**Addendum No. 1**

RE: Contract # C204684

**Haywood County (B-3186, B-5898)**

BRIDGES #155 AND 158 OVER RICHLAND CREEK ON US-23/74 AND  
BRIDGE #168 OVER US-19 AND US-23 ON US-23/74.

PREPARED BY
AECOM
NC FIRM LICENSE No. F-0342
5438 Wade Park Blvd., Ste 200
Raleigh, NC 27607
919-854-6200

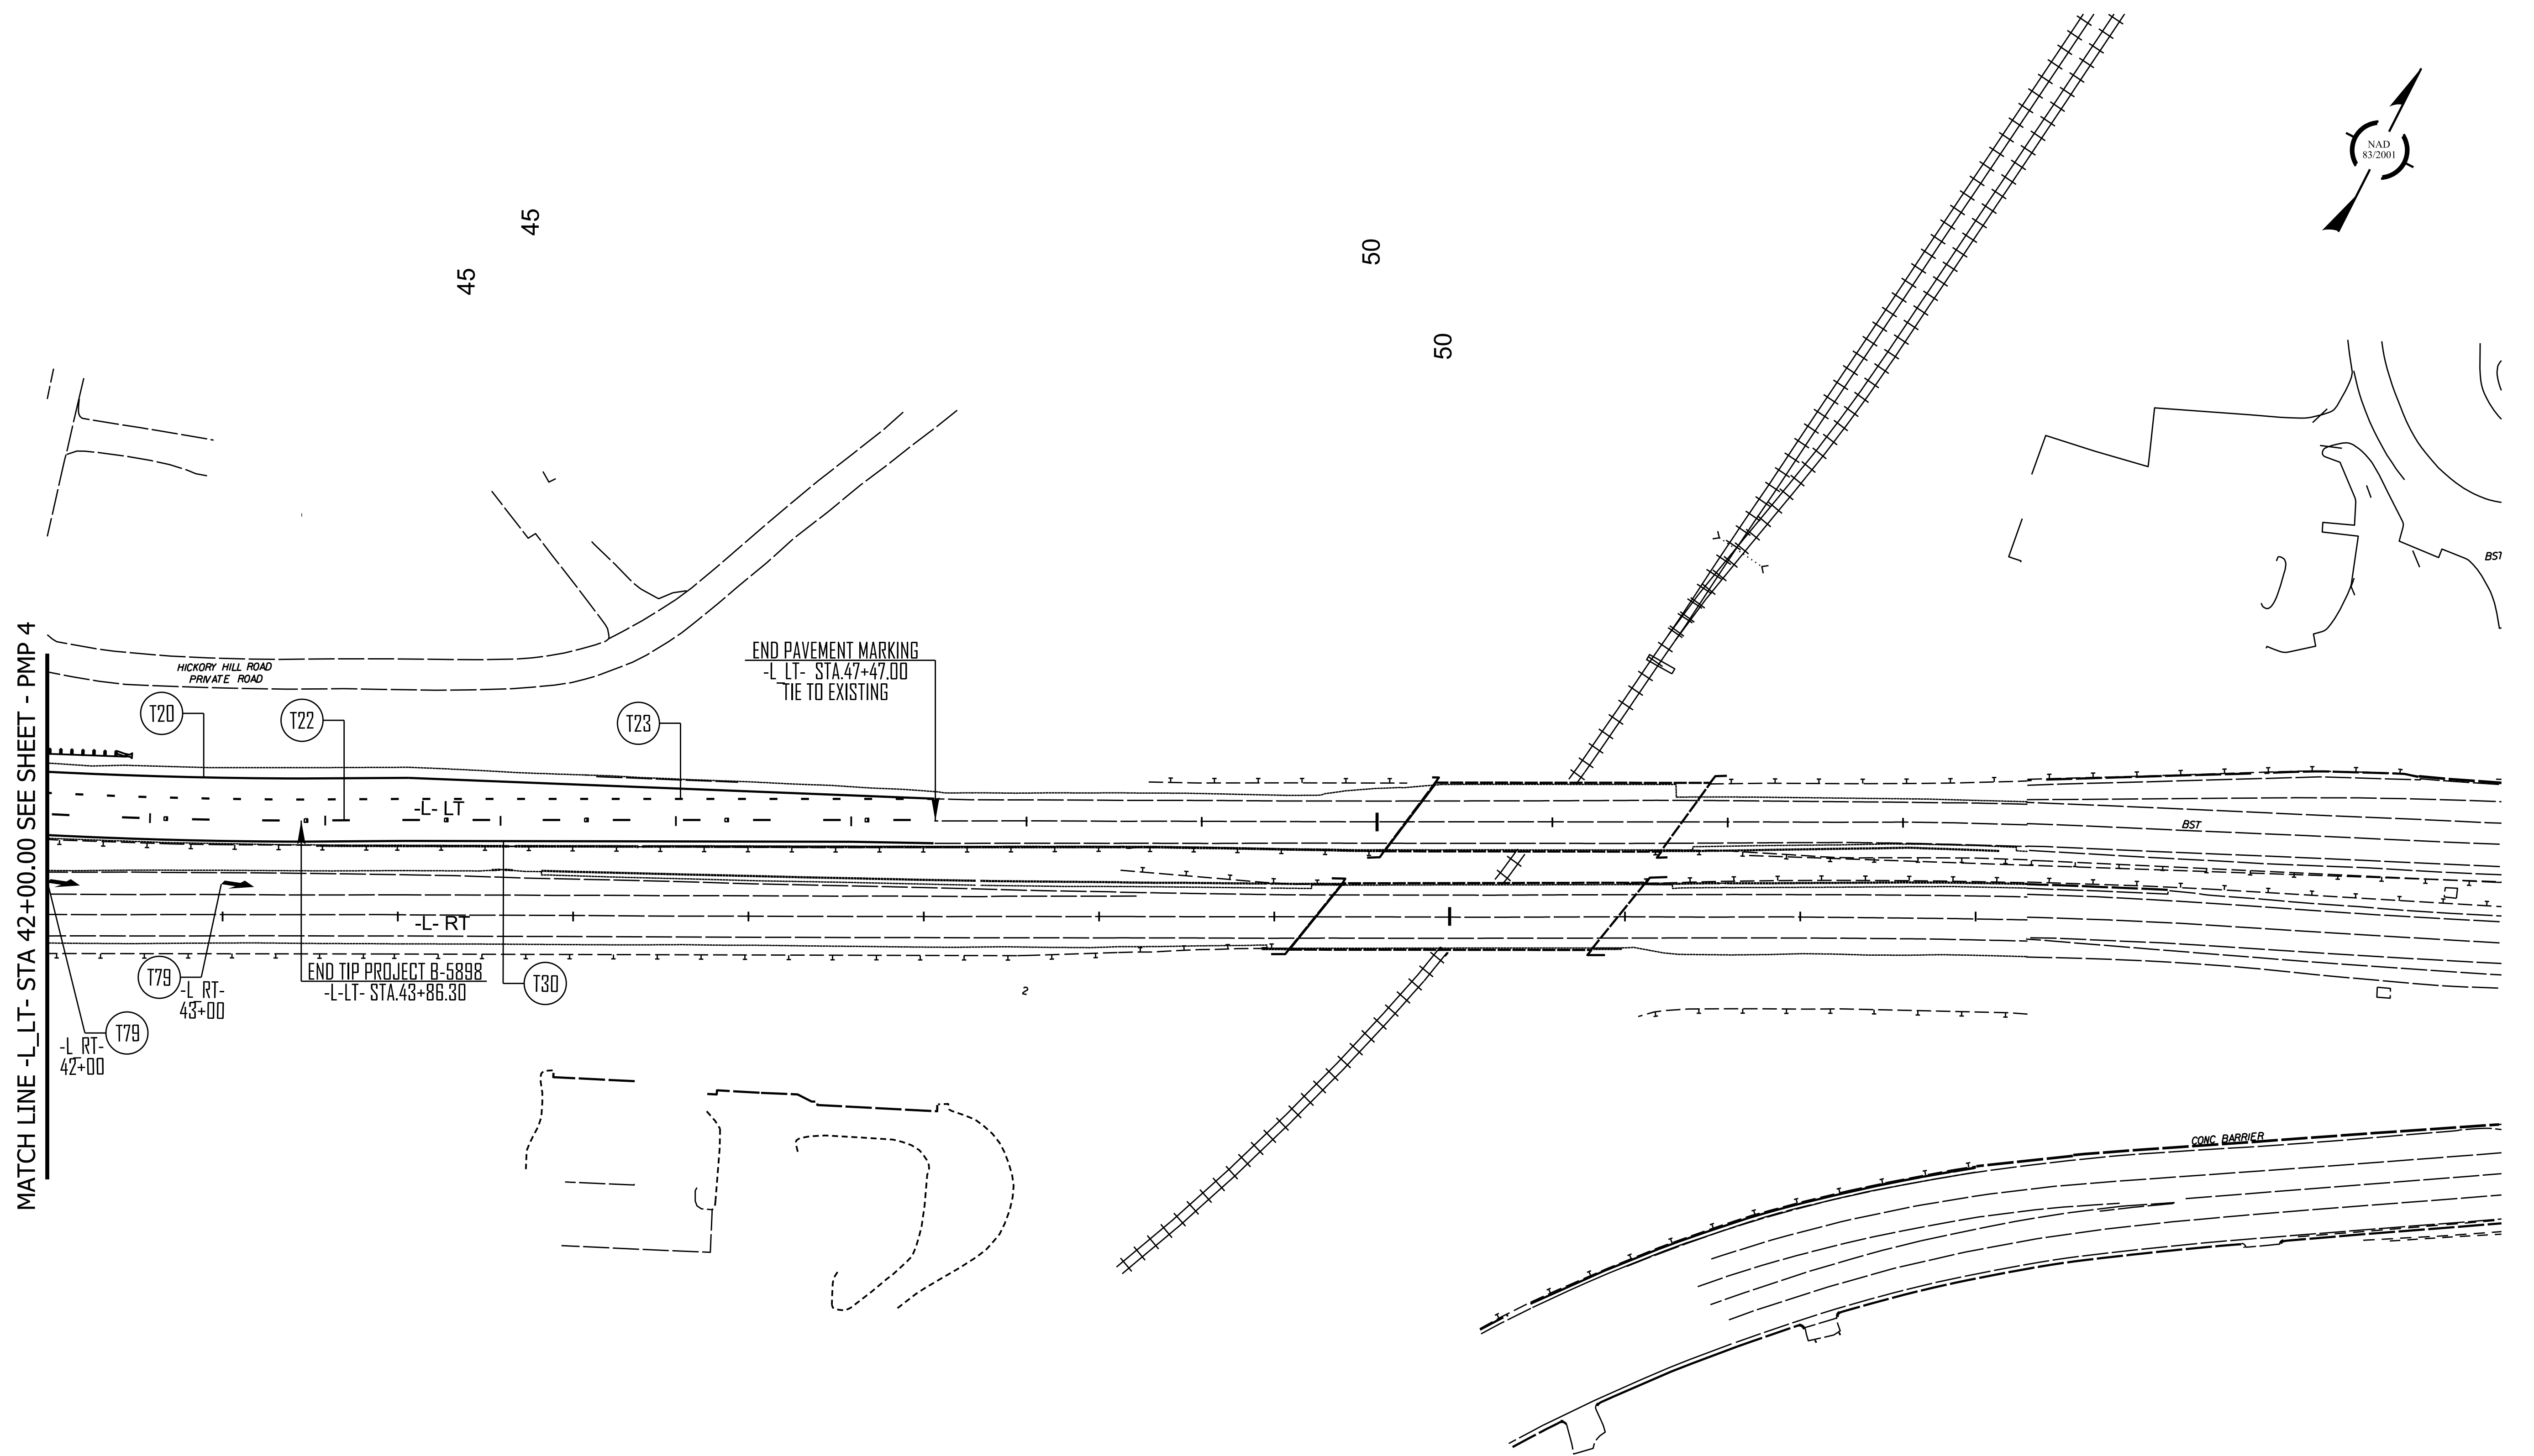
Sheet No.	Revision
PMP-1 thru PMP-5	Final Pavement Marking Schedule revised.
PMP-4 thru PMP-5	Merge arrows added, gore area striping revised.
